# GRADING AND EROSION CONTROL PLAN

## WYOMING ESTATES SUBDIVISION

### EL PASO COUNTY, CO

STANDARD NOTES FOR EL PASO COUNTY GRADING AND EROSION CONTROL PLANS

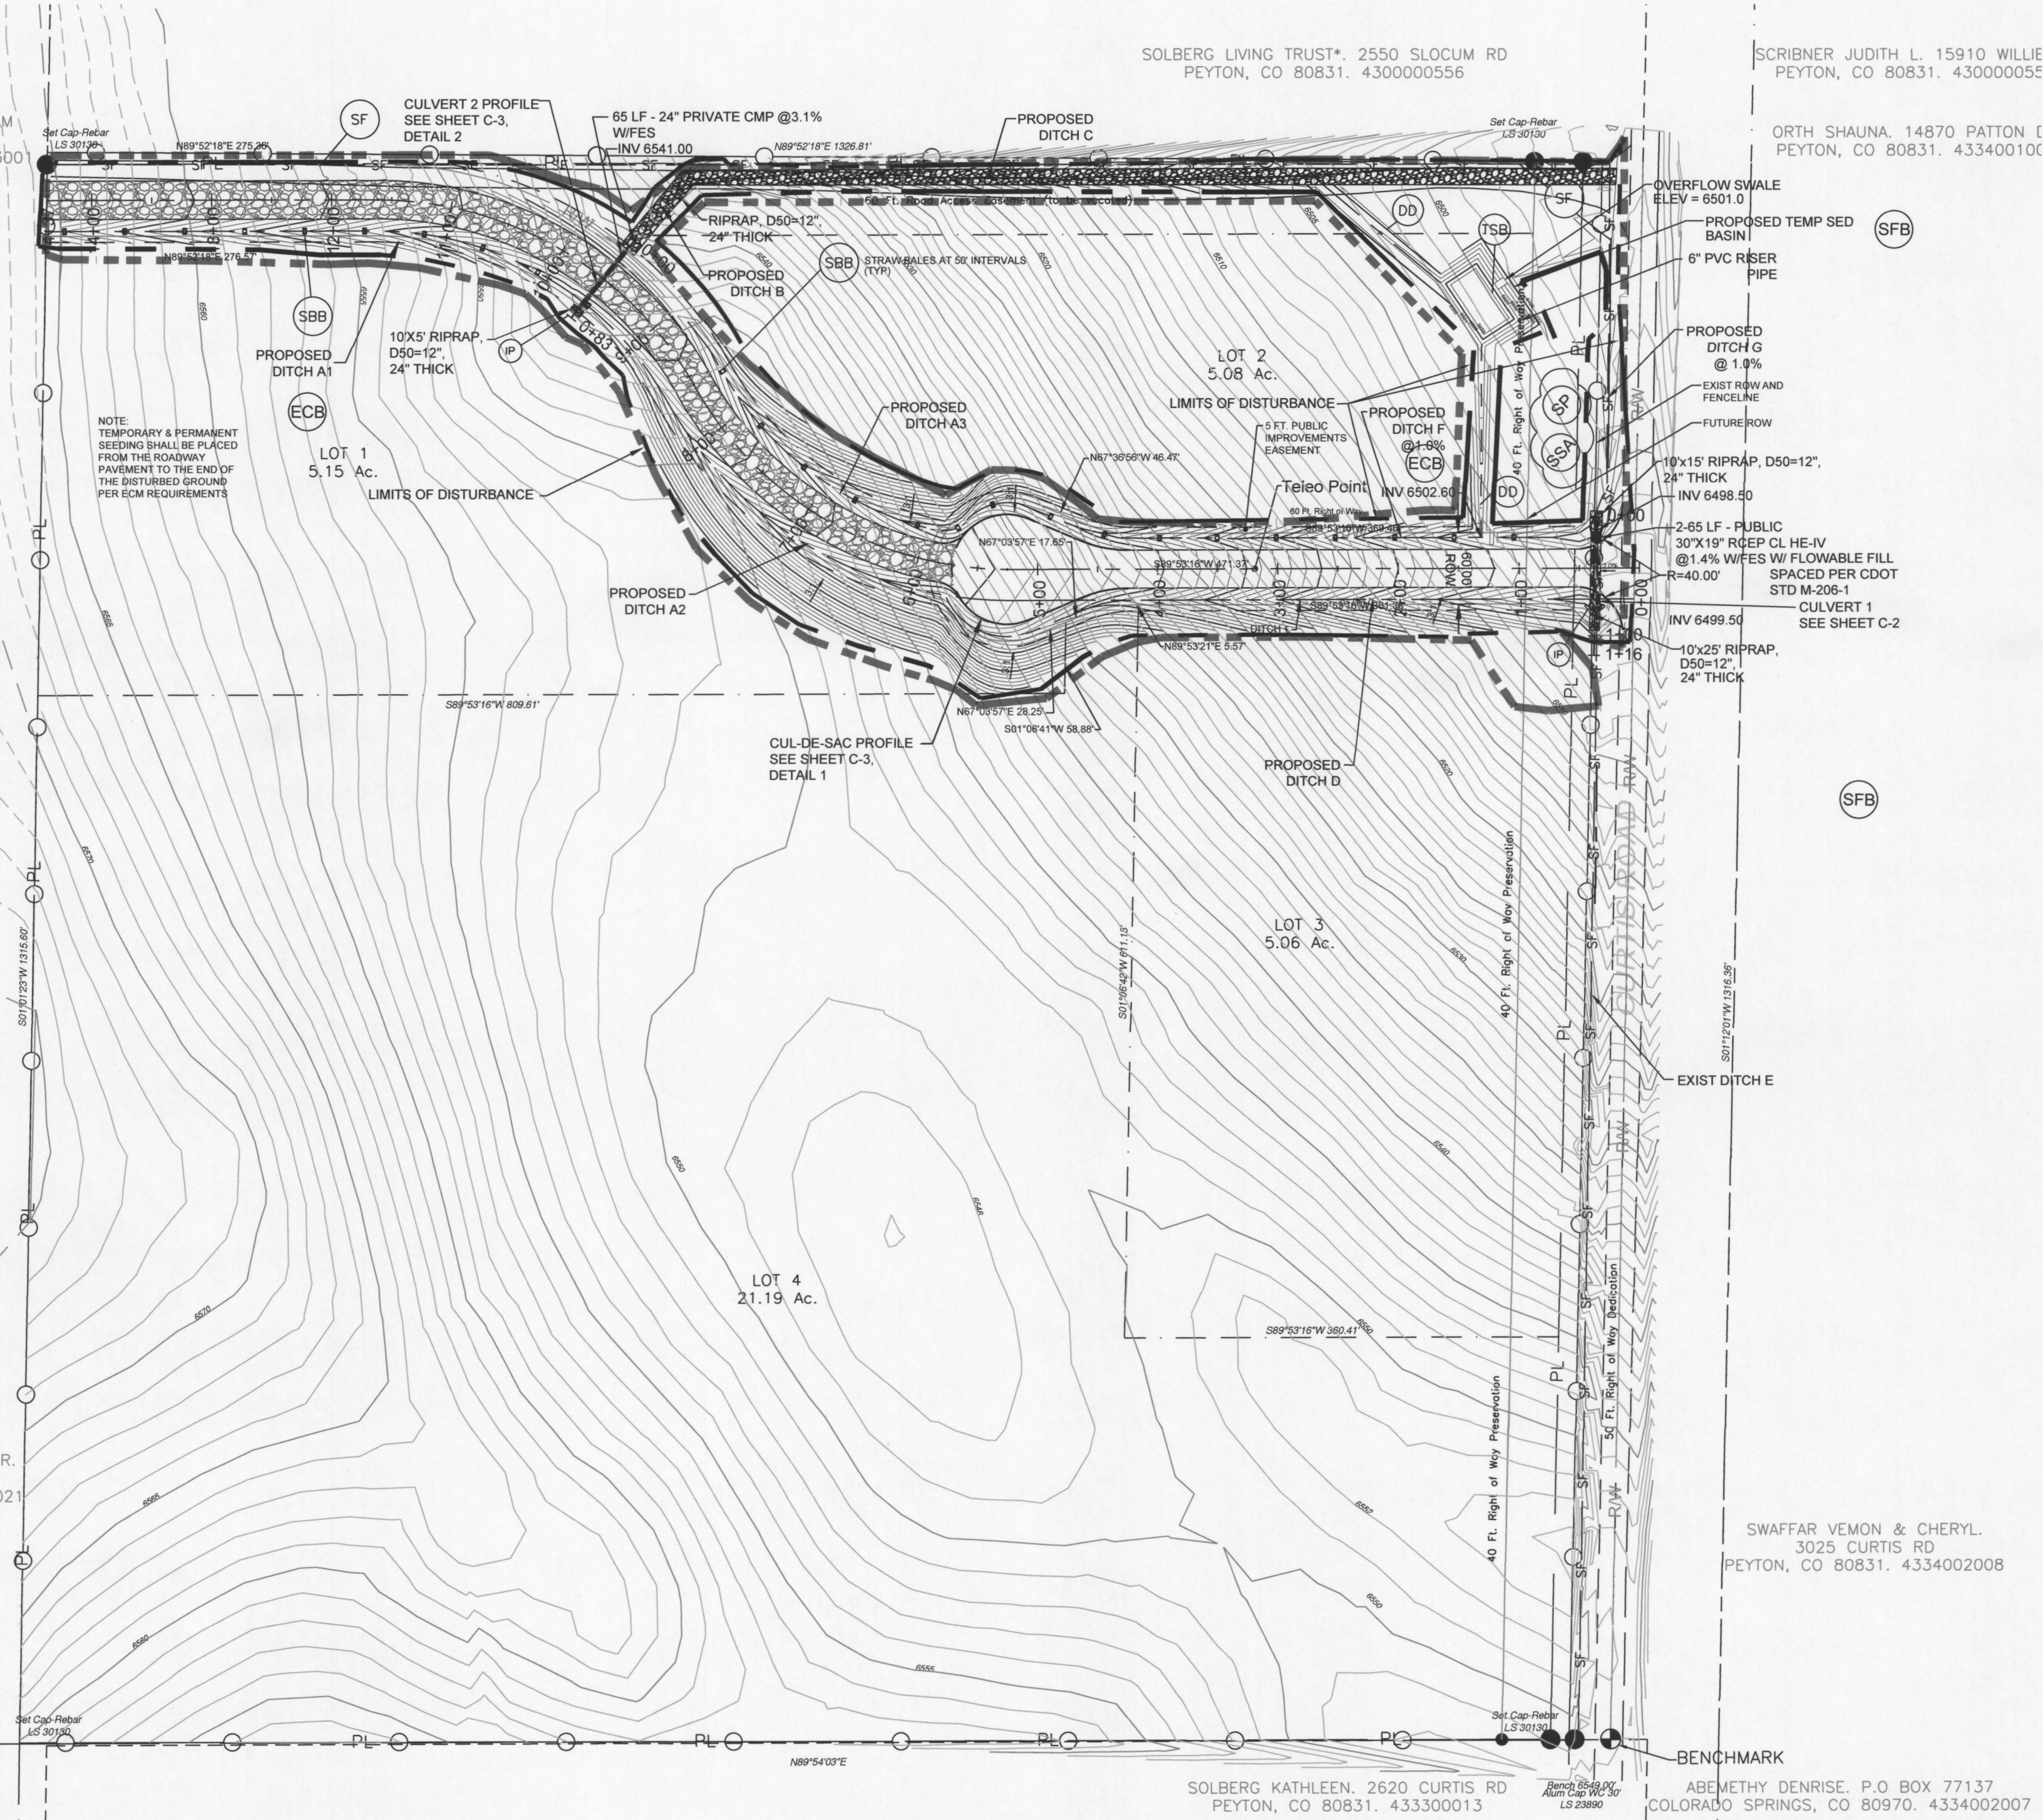
Add GEC Standard Notes (See GEC Checklist Section 3)

DRAINAGE, GRADING
AND EROSION
CONTROL PLAN

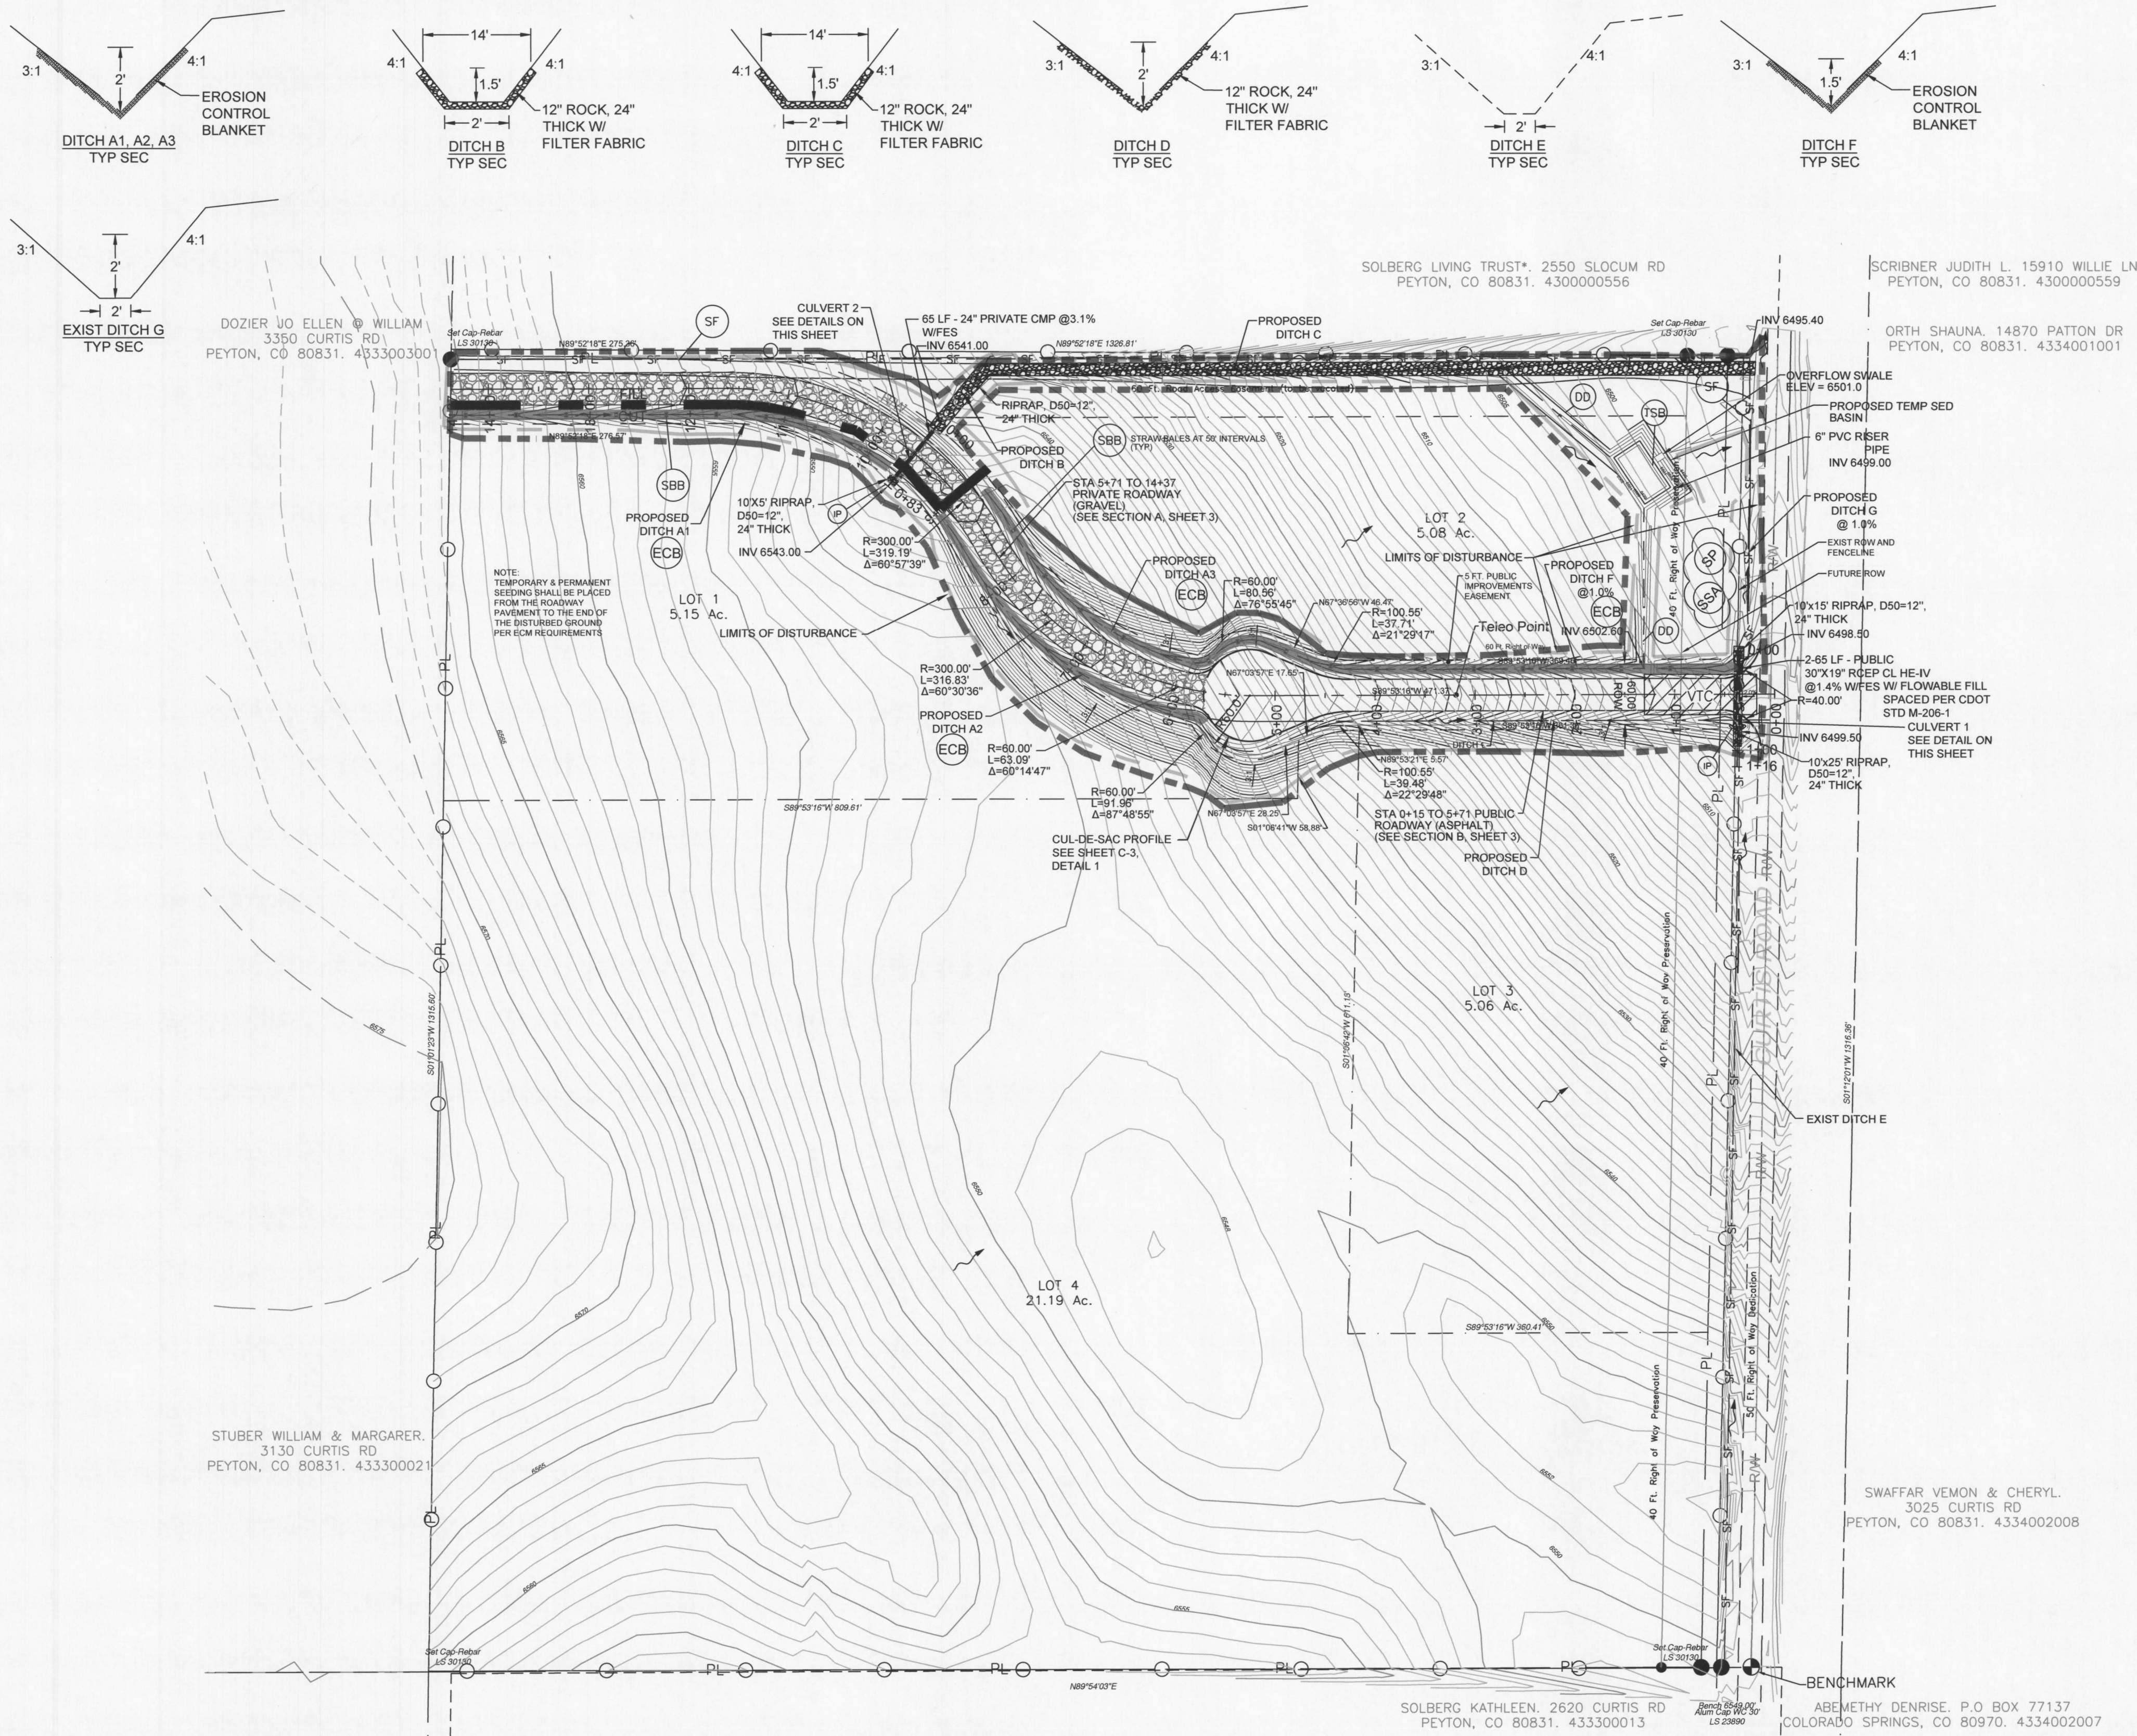
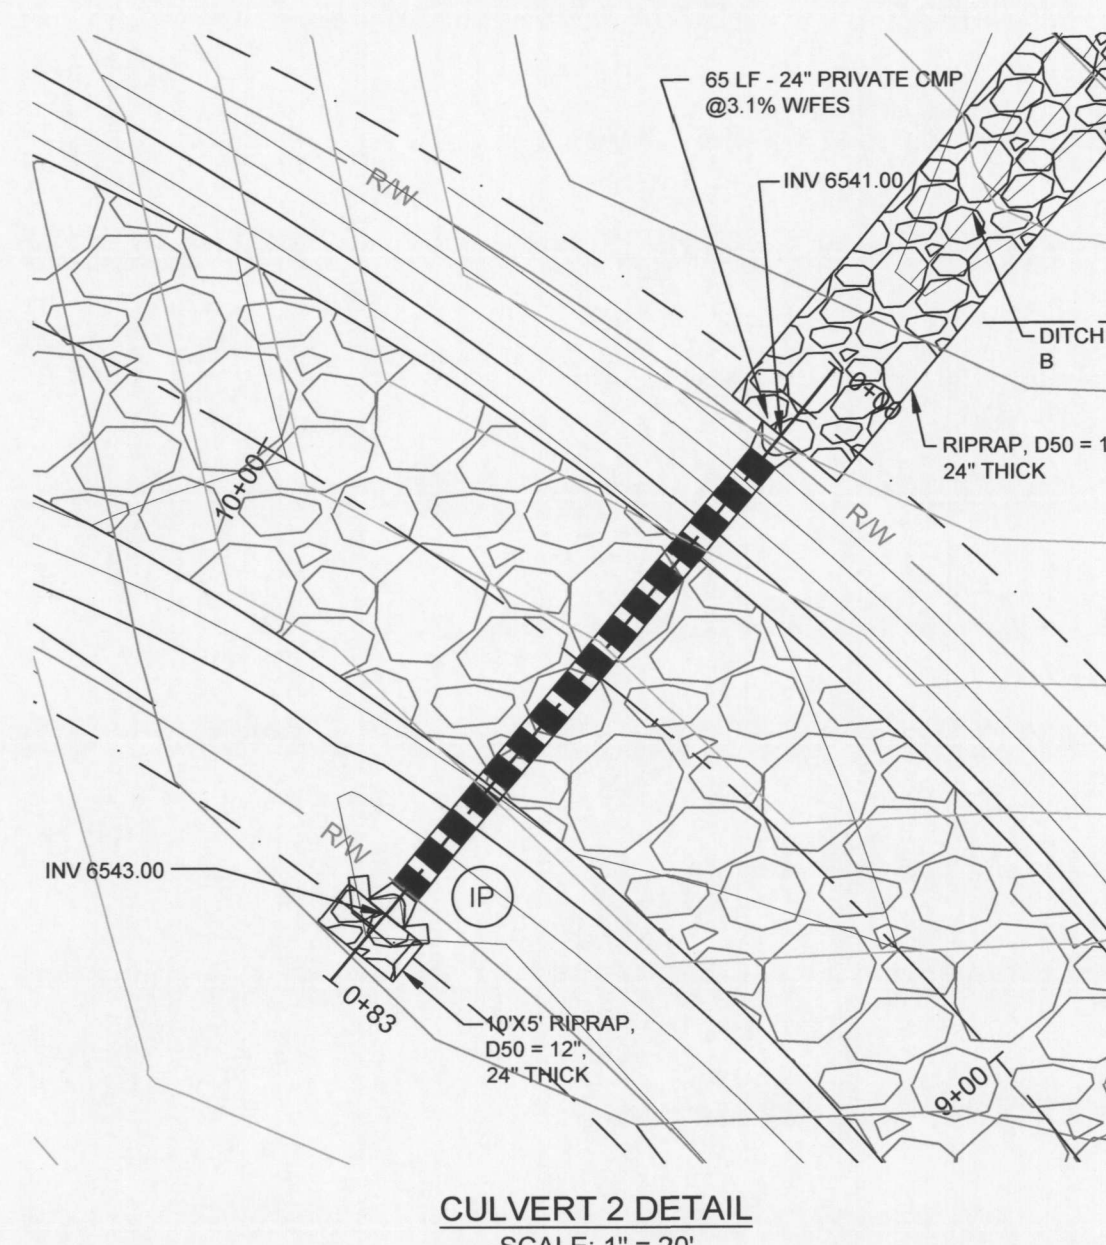
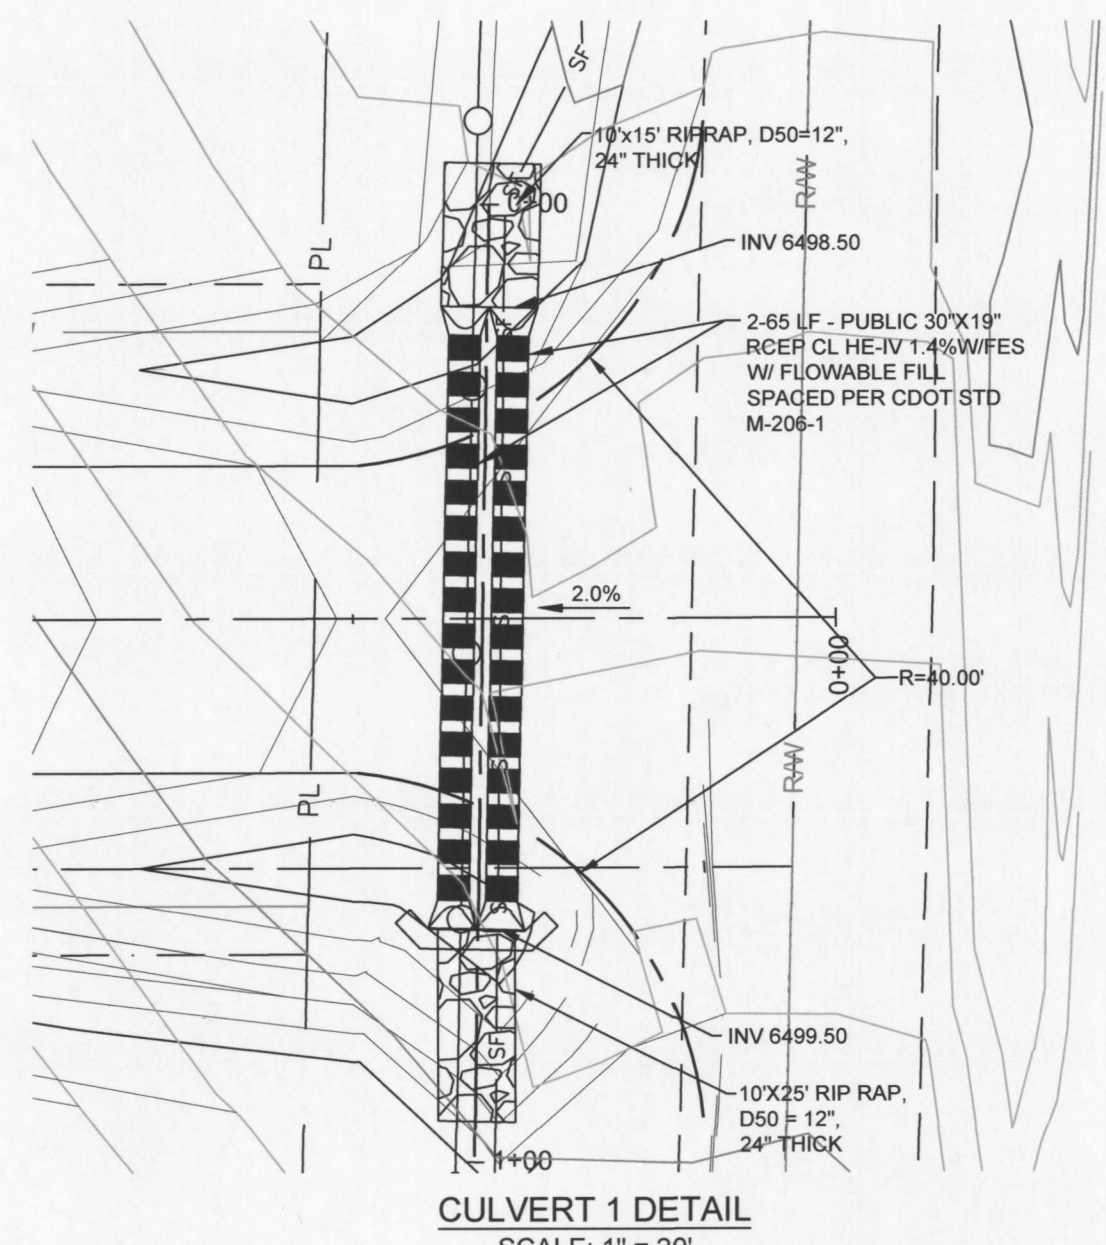
Show the following:  
 -stormwater flow arrows  
 -cut/fill areas  
 -seeding/mulching areas  
 -stabilized storage area  
 -location of concrete washout area (CWA)
